Fwd: D&B LIMITED TRUST LLC - A.Varela request for Alternative Landscaping plan & Pervious material credit

From: "Varela, Alan M." <avarela@cabq.gov>
Date: February 7, 2025 at 4:32:18 PM AST
To: Glass Co D&B <dbglassco@gmail.com>
Cc: DB LIMITED TRUST <dblimitedtrust@gmail.com>, "Biazar, Shahab" <sbiazar@cabq.gov>
Subject: RE: **D&B LIMITED TRUST LLC - A.Varela request for Alternative Landscaping plan & Pervious material credit**

The Planning Department carefully reviewed the request for a Director's approval of an Alternative Landscaping Plan with any landscaped area reductions allowed by law. I also received and reviewed the note you forwarded today with the baseball field idea from your architect.

Drawing file: 2-24-2025 / -AC3 PAVING PLAN.pdf

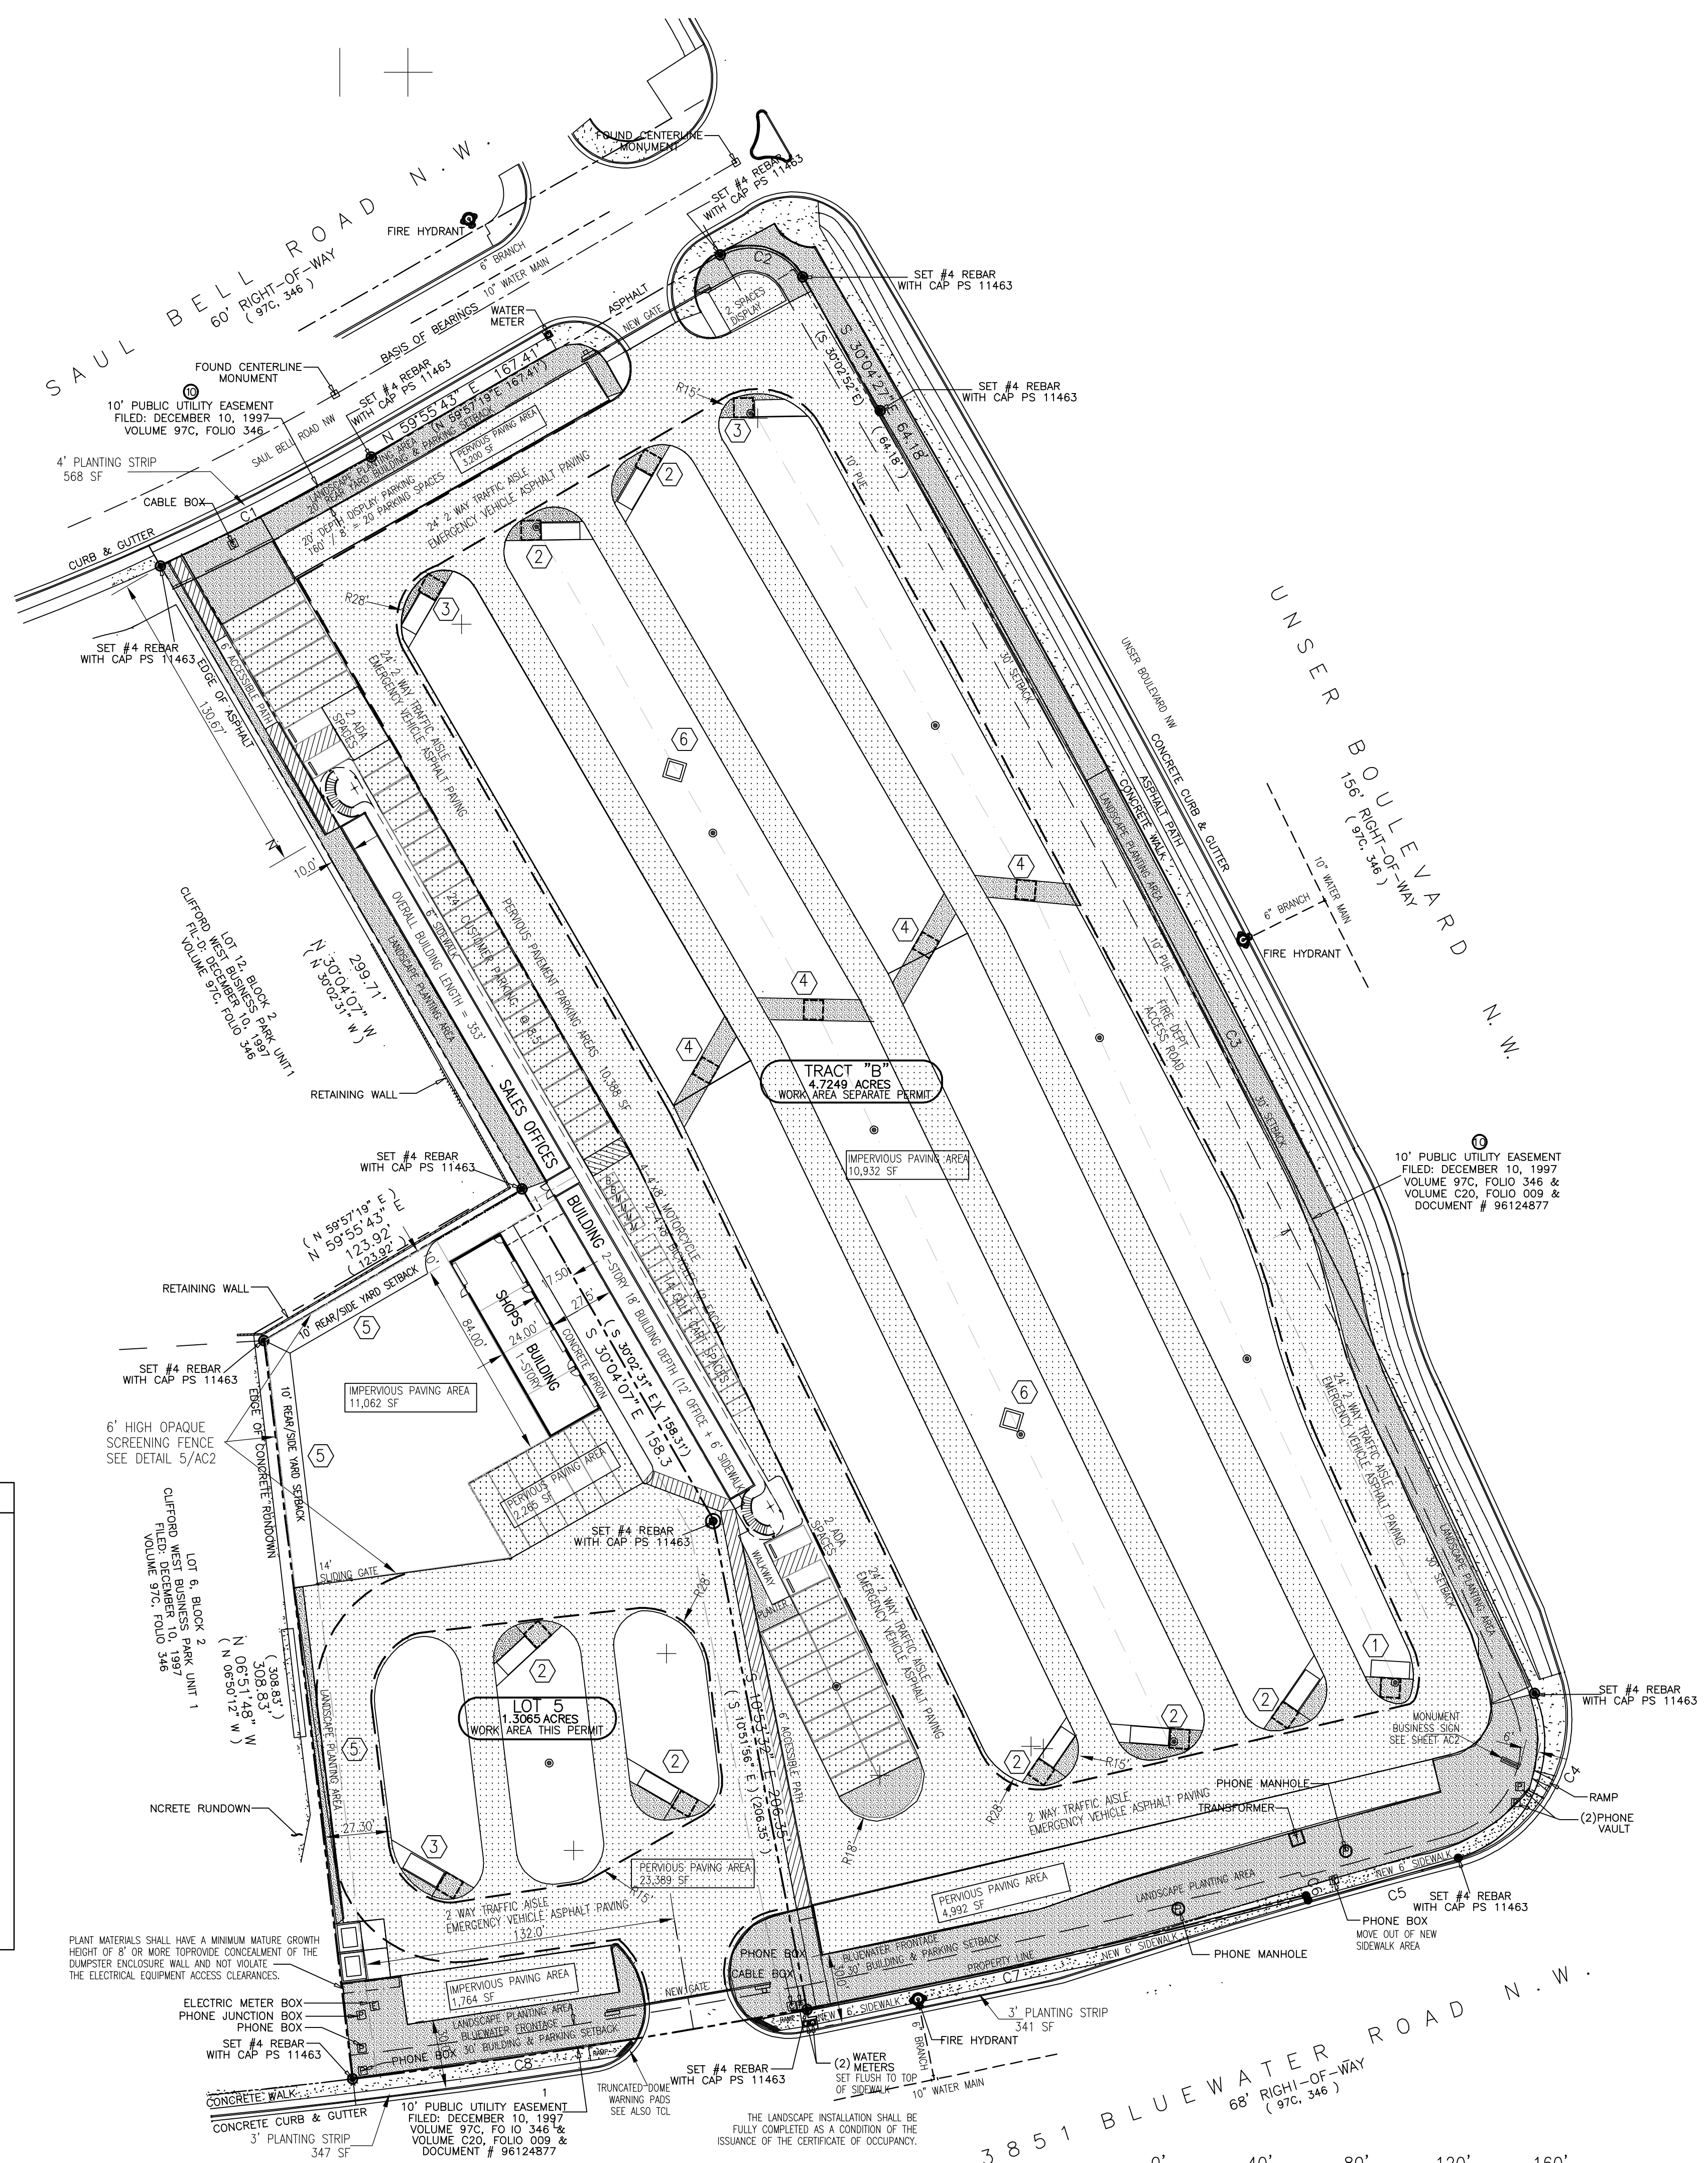
2. A reduction to 30,966 SF of landscaped area is approved on the following conditions:
 1. All parking areas and vehicle circulation areas and drive aisles must be permeable surfaces

2. The material for the permeable surfaces must be approved by the City Engineer or his designee
 3. The display areas do not need to be permeable, but that is preferred

Drawing file: PR-2024-010446_SP-2025-00015_Alternative_Landscape_Plan / PR-2024-010446_SP-2025-00015_ALP_3-20-25.pdf

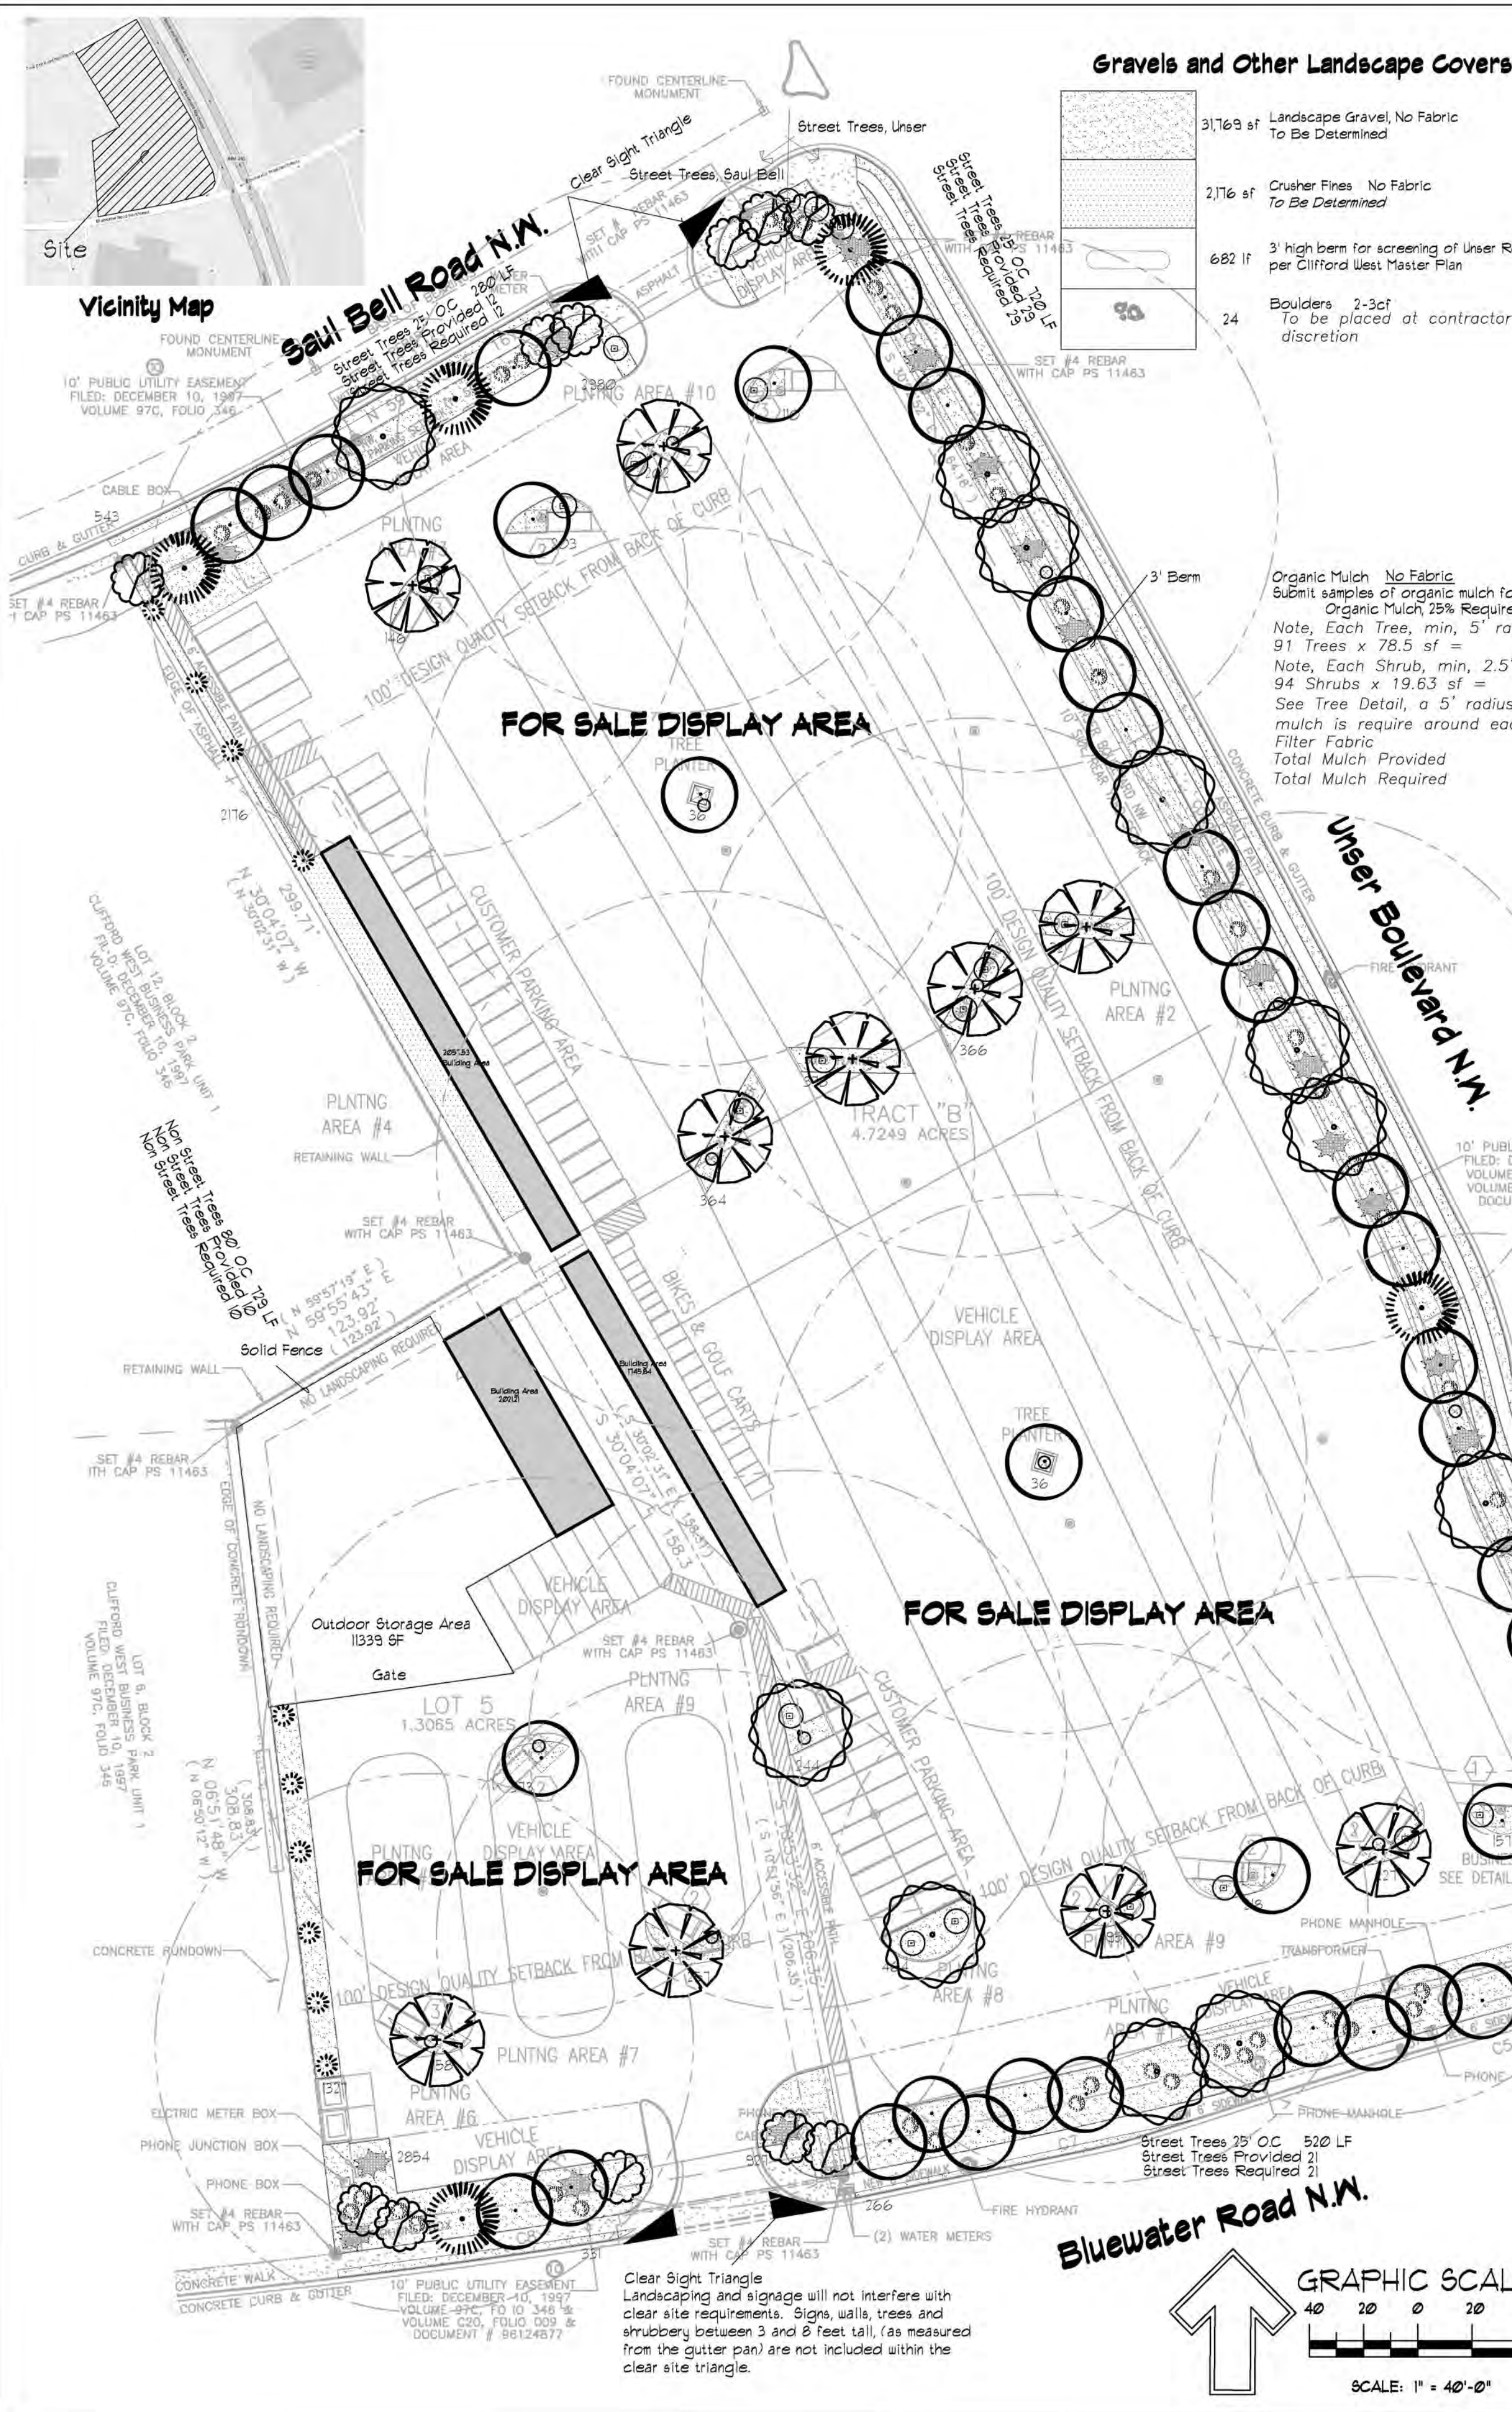
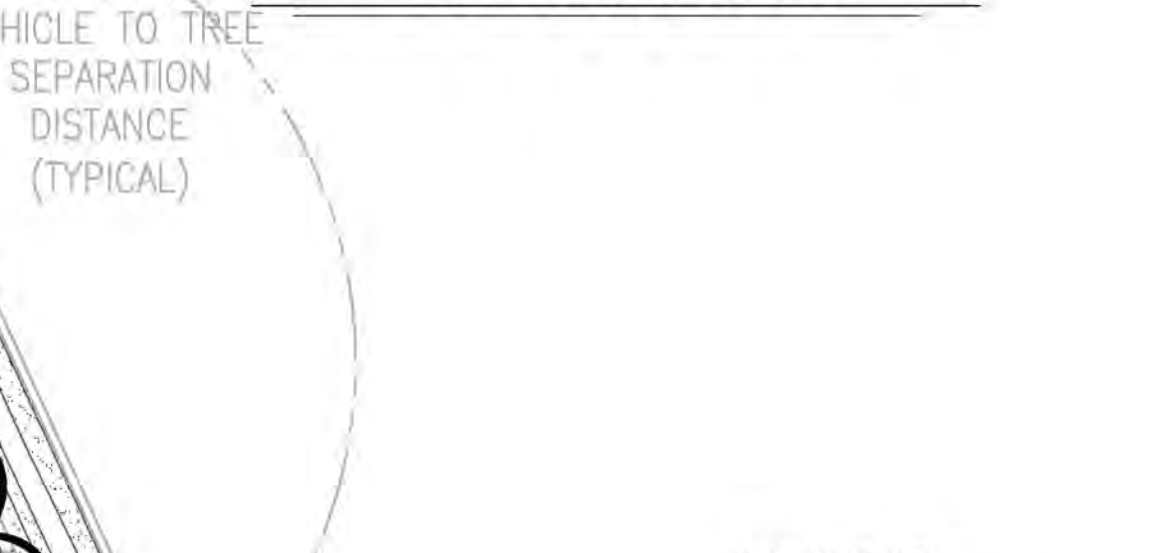
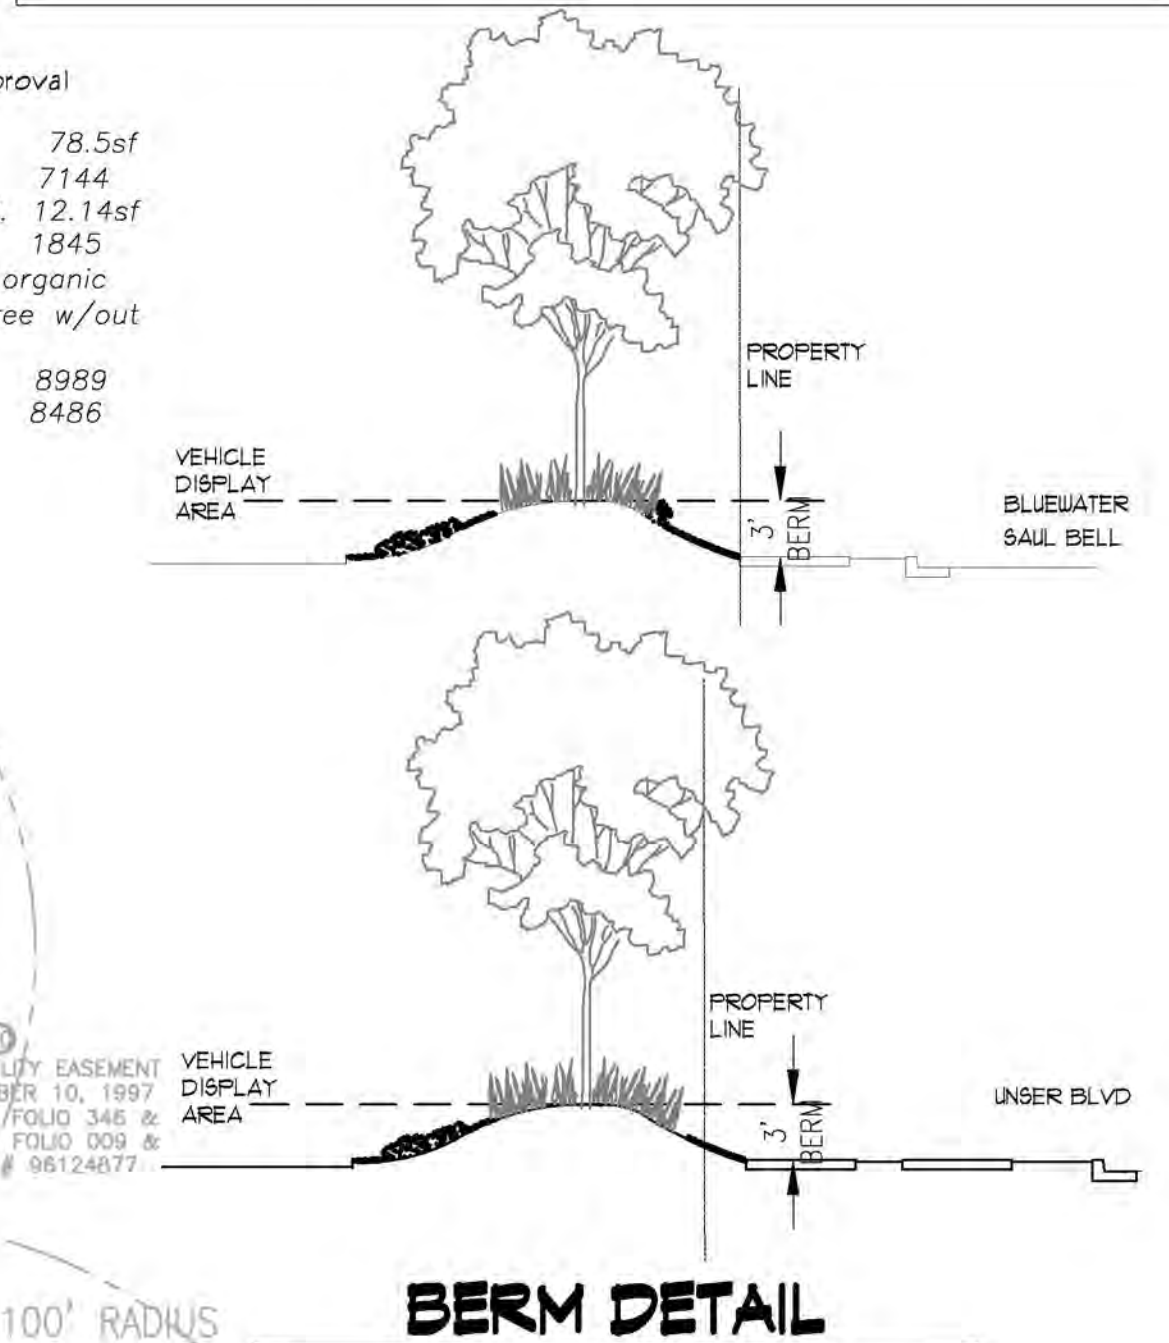
1. The number of proposed trees in the most recently submitted Alternative Landscaping Plan is acceptable and must be provided for the site: **91 trees**

3. **If, and only if, all the above conditions are satisfied**, then an additional 10% deviation from the pre-deduction landscaped area of 41,288 SF is hereby authorized, i.e., a further reduction of 4,128 SF which reduces the absolutely required landscaped area for this site to 26,838 SF. Thus, to help this project move forward, the possible overall reduction to 26,838 SF of landscaped area is also hereby approved through my authority as the Planning Director, and any further reductions simply will not be considered. (This is *not* a baseball field.)
